KIRKLEES METROPOLITAN COUNCIL INVESTMENT & REGENERATION SERVICE

DELEGATED DECISION TO DETERMINE APPLICATIONS FOR LISTED BUILDING CONSENT

Reference No:	2023/65/92815/W
Site Address:	Chicken Cottage, 23, Cross Church Street, Huddersfield, HD1 2PY
Description:	Listed Building Consent for erection of single storey rear extension, alterations to upper floors to form 2 apartments, alterations to frontage to create additional entrance, internal and external alterations
Recommending Officer:	Katie Chew

DECISION – Refuse listed building consent

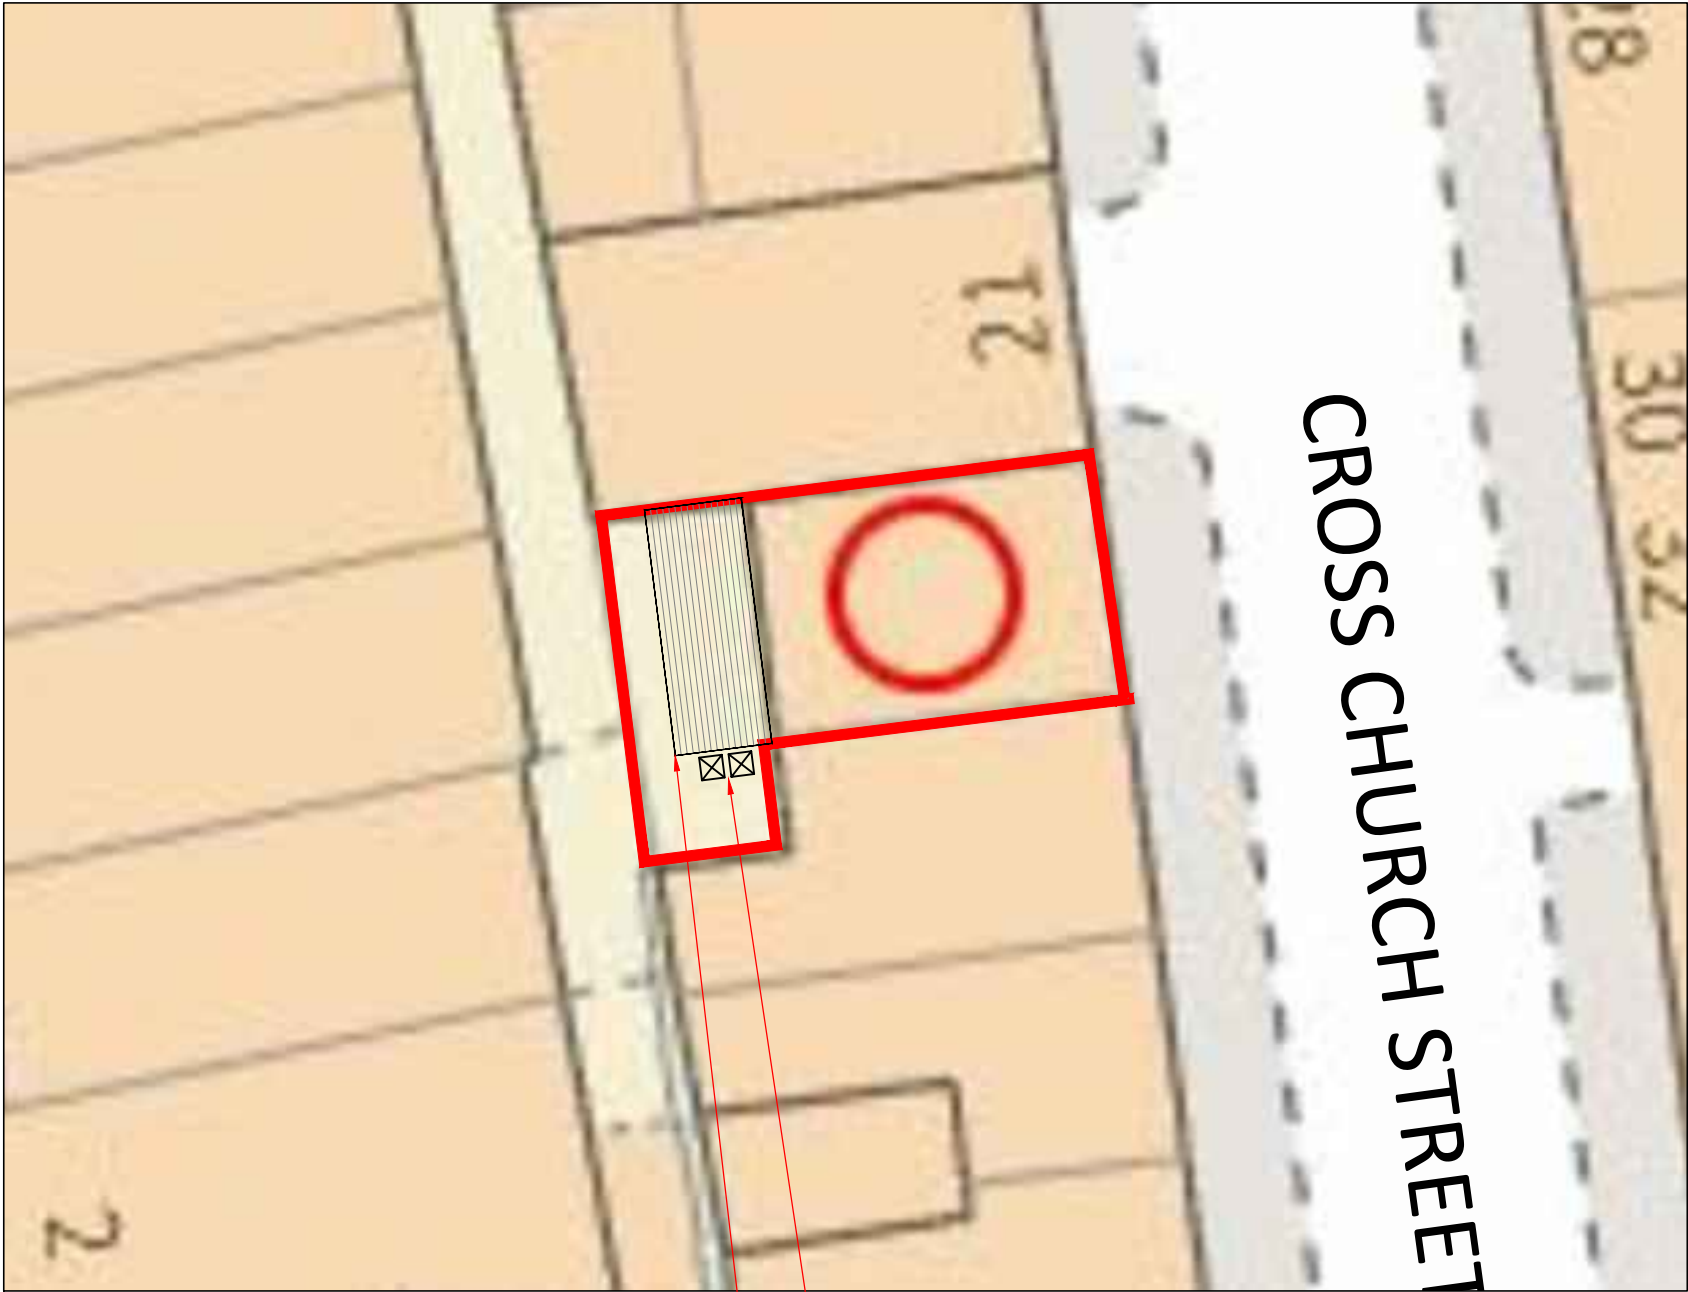
The proposed single storey extensions is to be erected on the rear elevation of the existing property and is to measure 6.1m x 2.5m, with a ridge height of 2.8m. The extension is to be constructed from stone with a flat roof and is to provide an extended kitchen/prep area to Chicken Village.

C&D Officers also note that the proposed extension to the rear should have no impact on the setting and significance of the Listed Building, but again further details are required to ensure that it is constructed sensitively. In principle, the conversion of the upper floors of 23 Cross Church Street and a single storey rear extension could be acceptable subject to the proposals being sympathetic but without the submission of further information Officers are unable to undertake a full assessment of the scheme. With the overall main concern being the lack of assessment and understanding of the significance and character of the building.

TITLE
PROPOSED SECTION

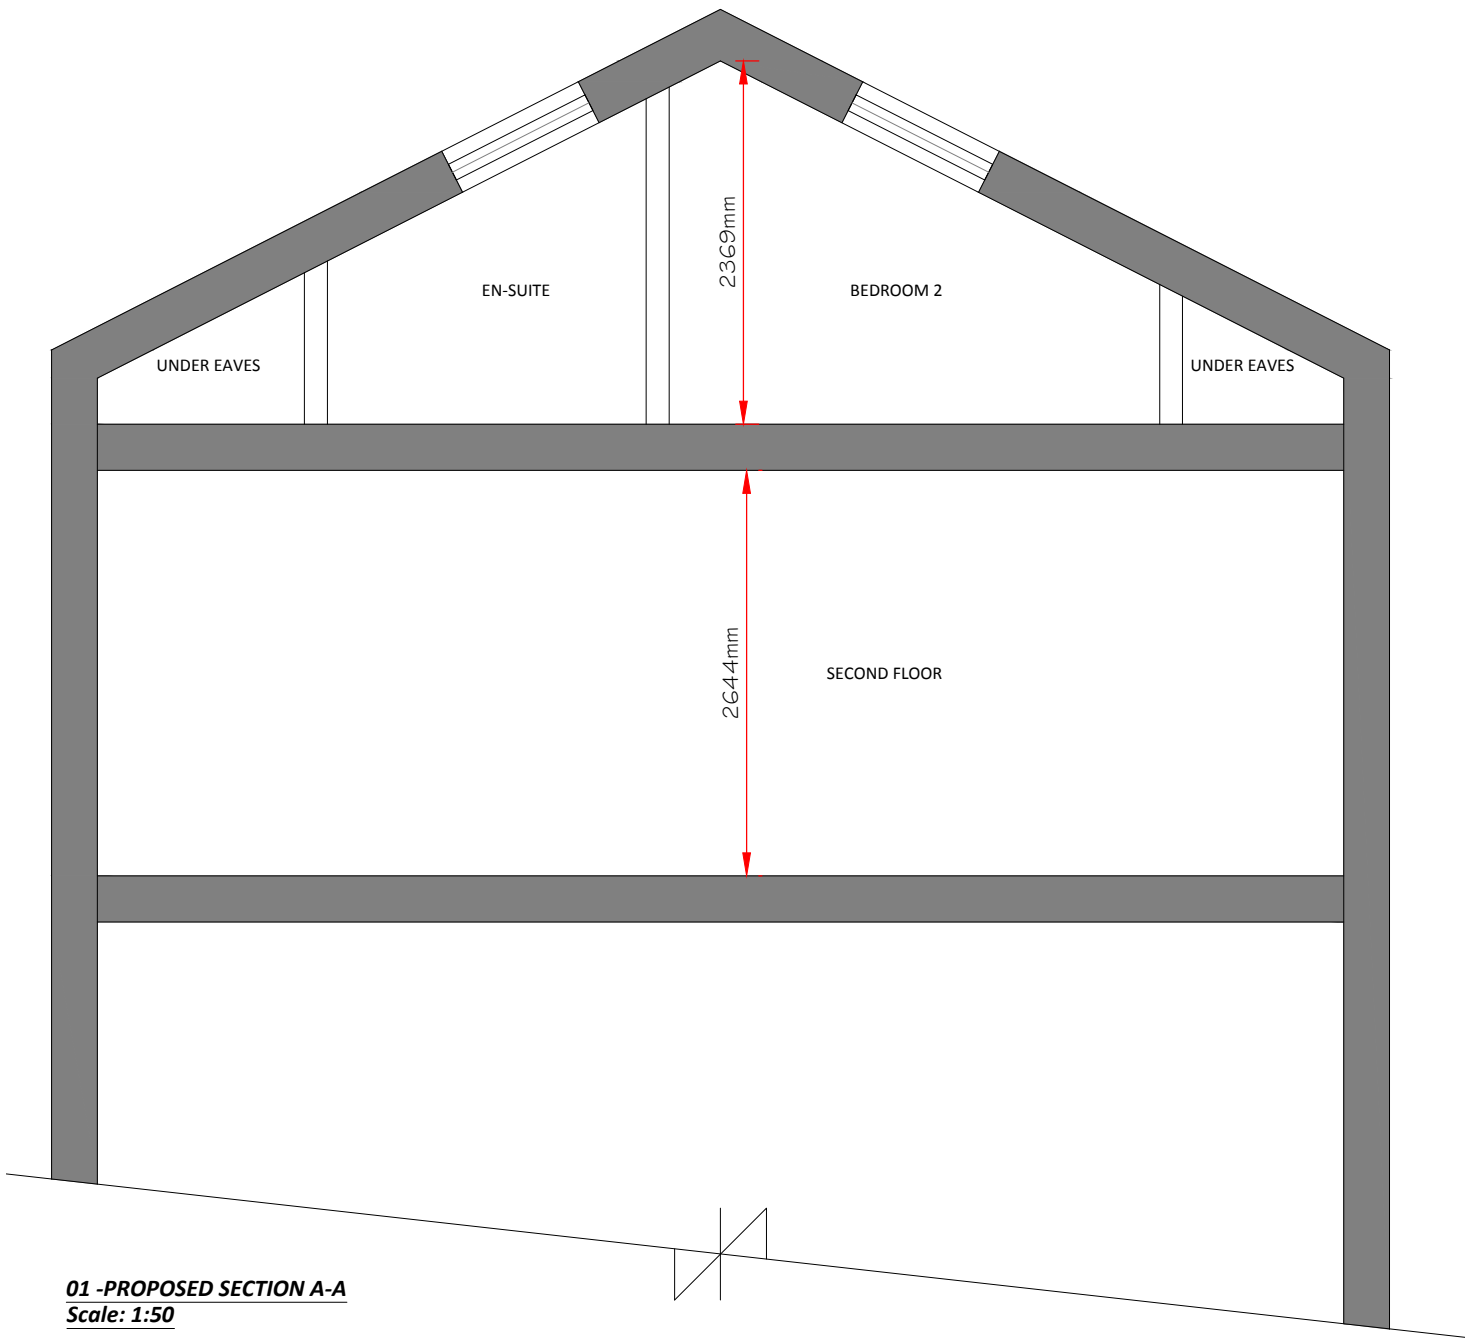
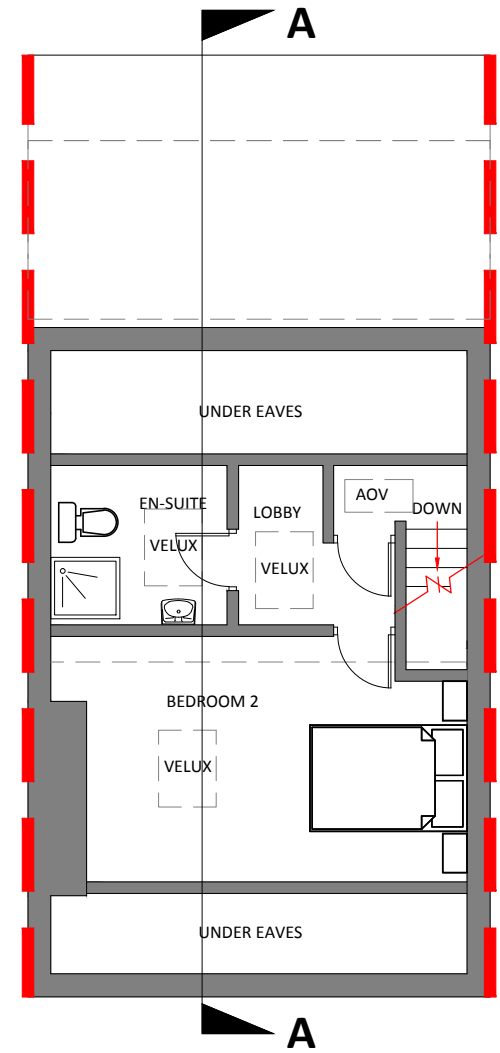
In respect of the proposed internal and external alterations, insufficient details have been provided and although internal photographs have been submitted, no information has been given on how the removal, installation or retention of certain structures/features such as the staircase, internal walls, installation of rooflights etc. are to be undertaken to ensure that the fabric of the Listed Building is protected and enhanced where possible. Of note, the existing staircase looks to be a rare surviving element of the Listed Building and therefore its removal/alteration could significantly impact on the significance of the building.
